**From:** Russell Hand <RHand@cityofsydney.nsw.gov.au>  
**Sent:** Wednesday, 21 October 2015 2:28 PM  
**To:** Alexander Scott  
**Cc:** Christopher Corradi  
**Subject:** Barangaroo R1 Response to Submissions including fitout and use

I refer to Lend Lease's Response to Submissions (RtS) on Barangaroo South Building R1 (SSD 6513).

# ground floor plan

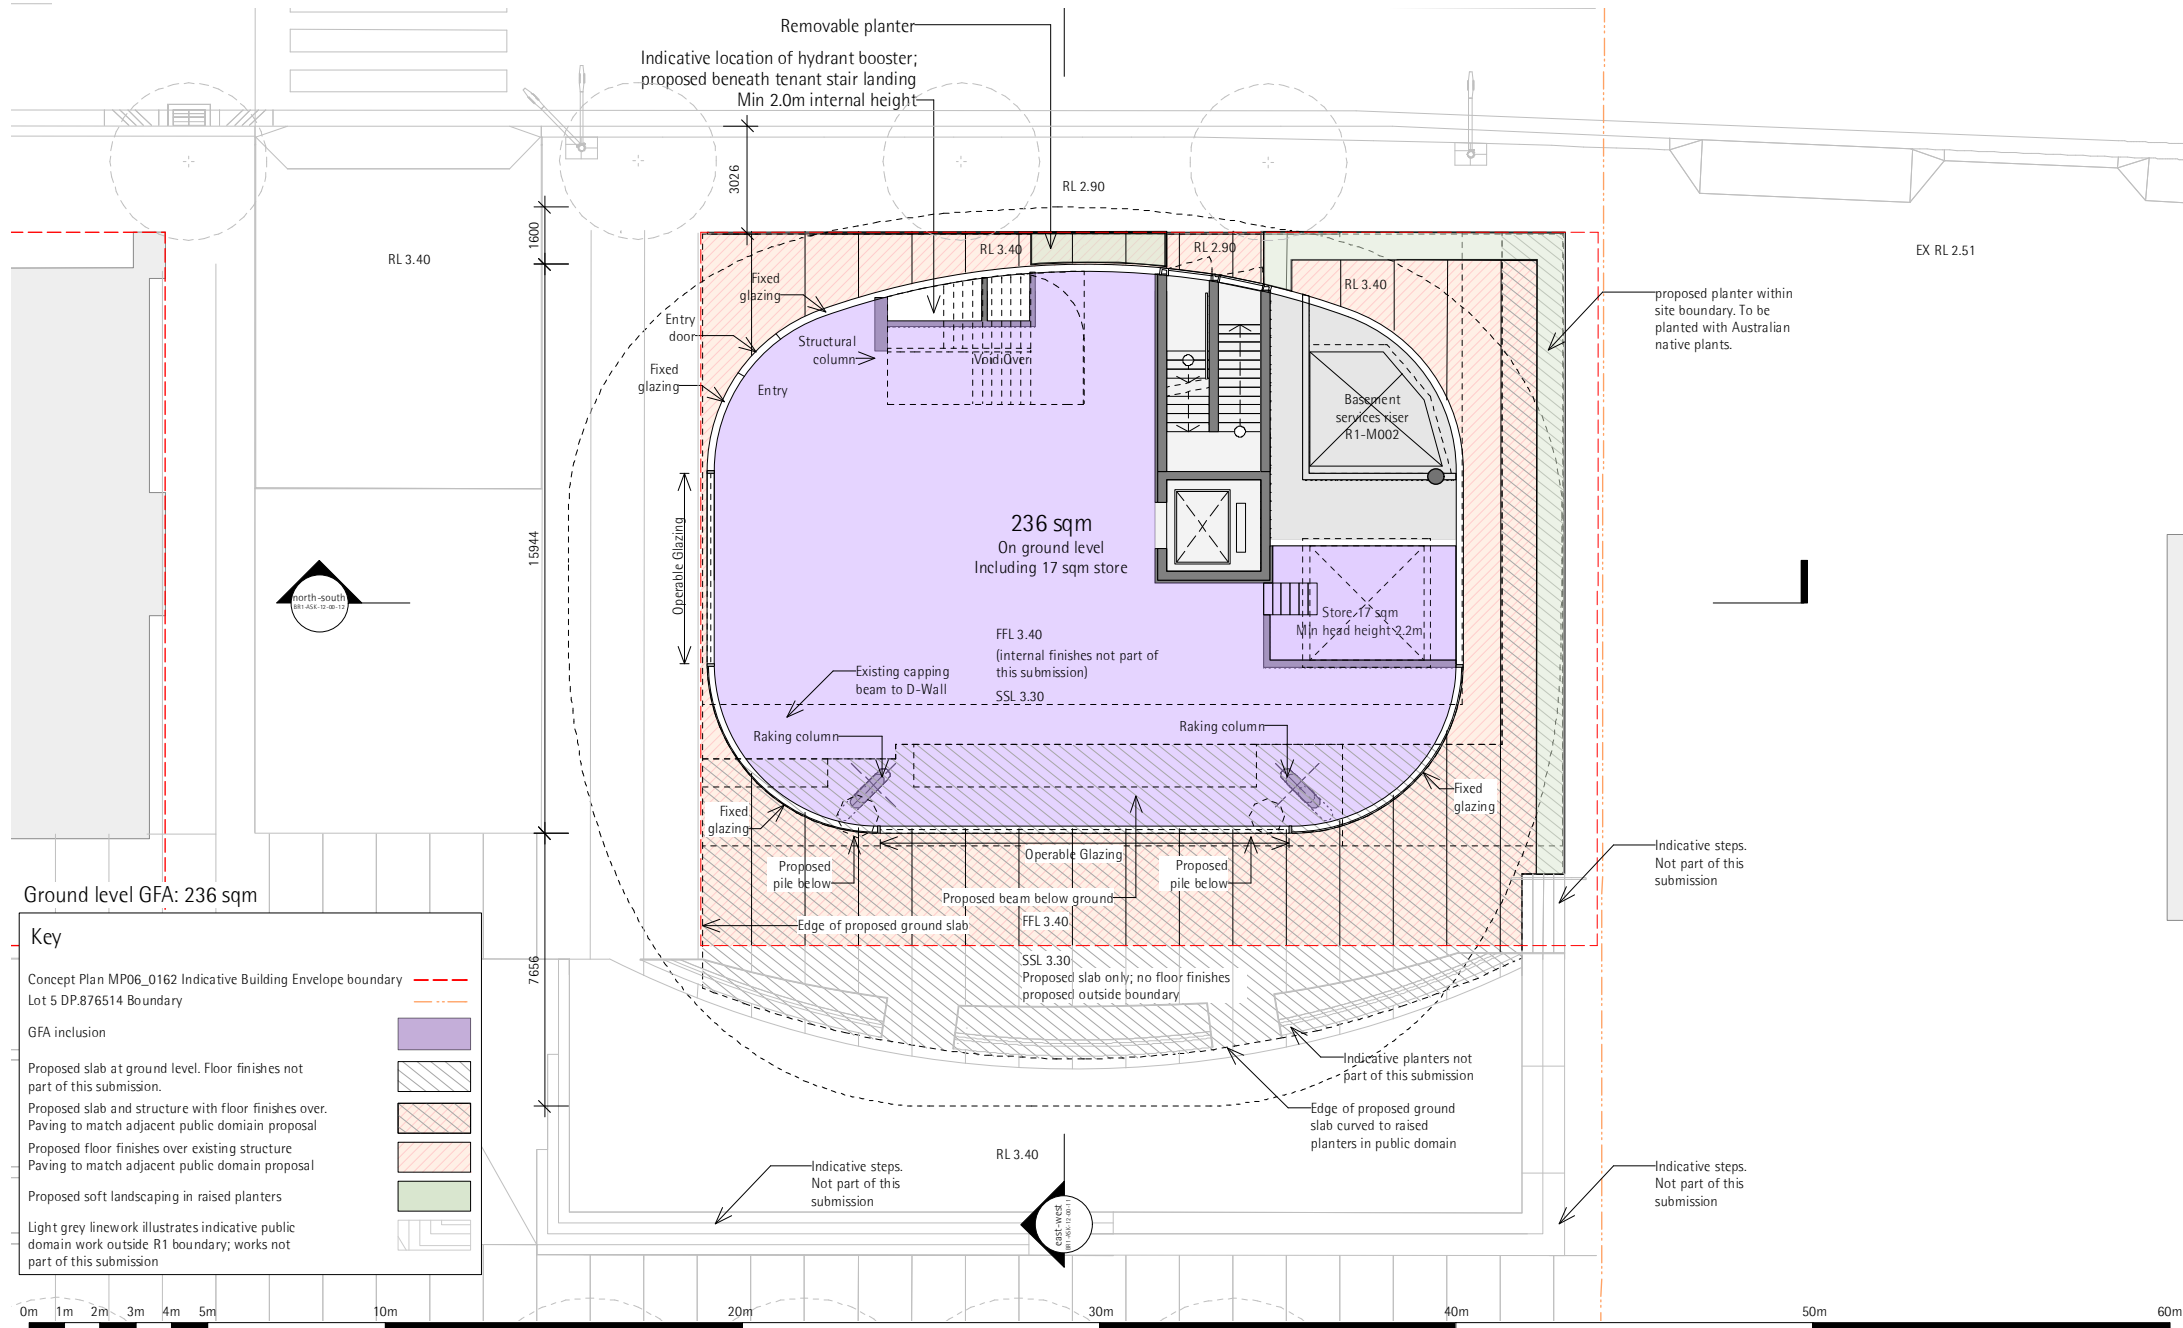
- the design changes have had the opposite effect from what was desired in terms of increased plant and service areas to the south and east at the ground floor. Accordingly, the City continues to recommend that the Department ensure a high quality exterior finish is achieved along these blank frontages;
- the City questions the introduction of a new patron access point at the north-eastern corner of the building and recommends that use of the entry/exit be highly controlled to minimise disturbance on the adjacent residential premises; and
- notations on the DA drawings for the roof have changed from "photovoltaic panels" to "potential location of photovoltaic panels". The Applicant's intentions in this regard should be confirmed. In the event that

# roof plan

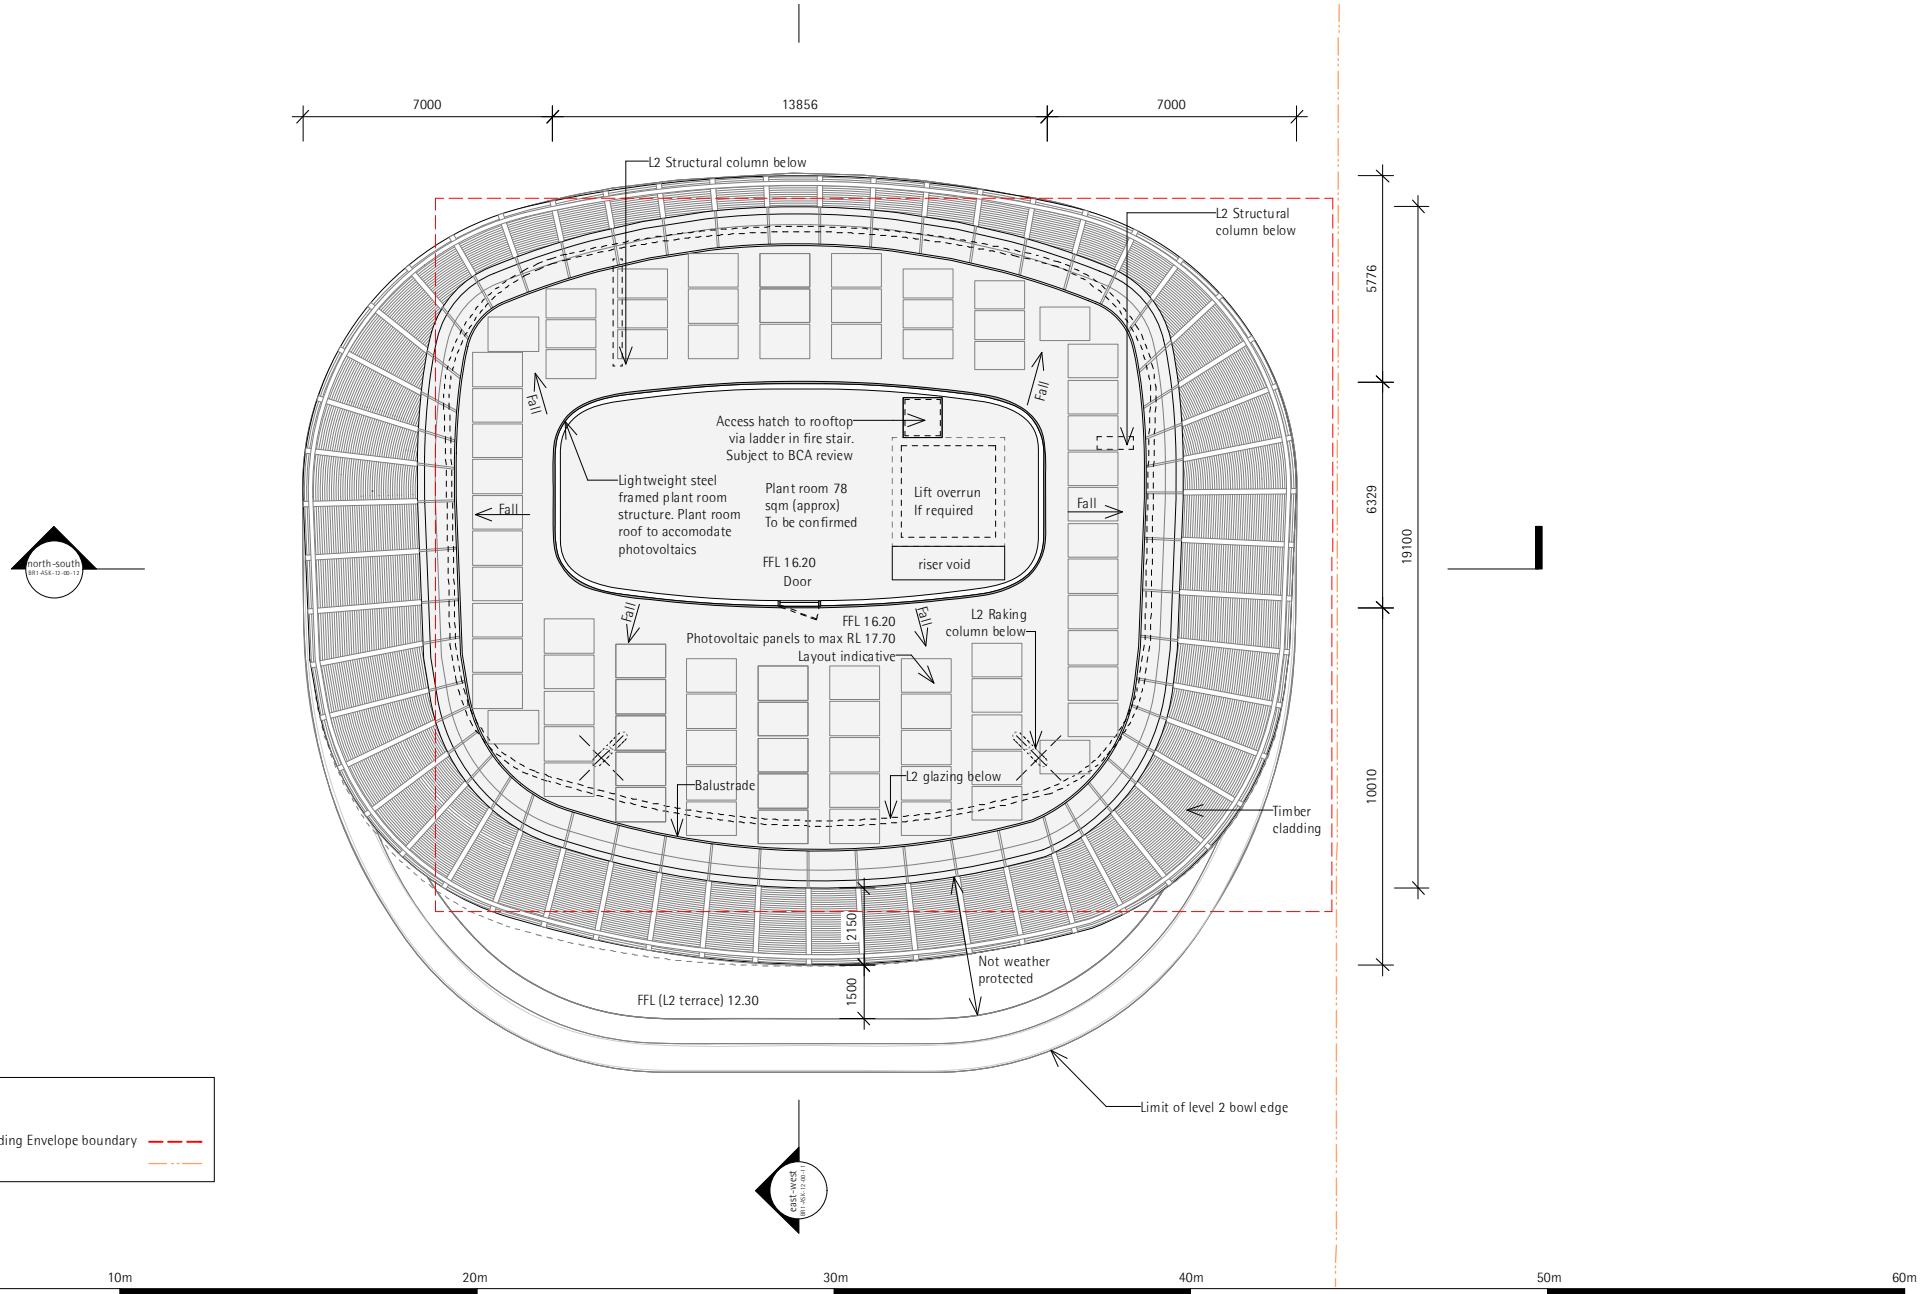
photovoltaics are not pursued the roof should be a green roof to compliment the landscaping of the lower levels and rooftop gardens of Building R9 adjacent. The amount of other buildings looking down upon the roof warrants a pleasing, landscaped aesthetic.
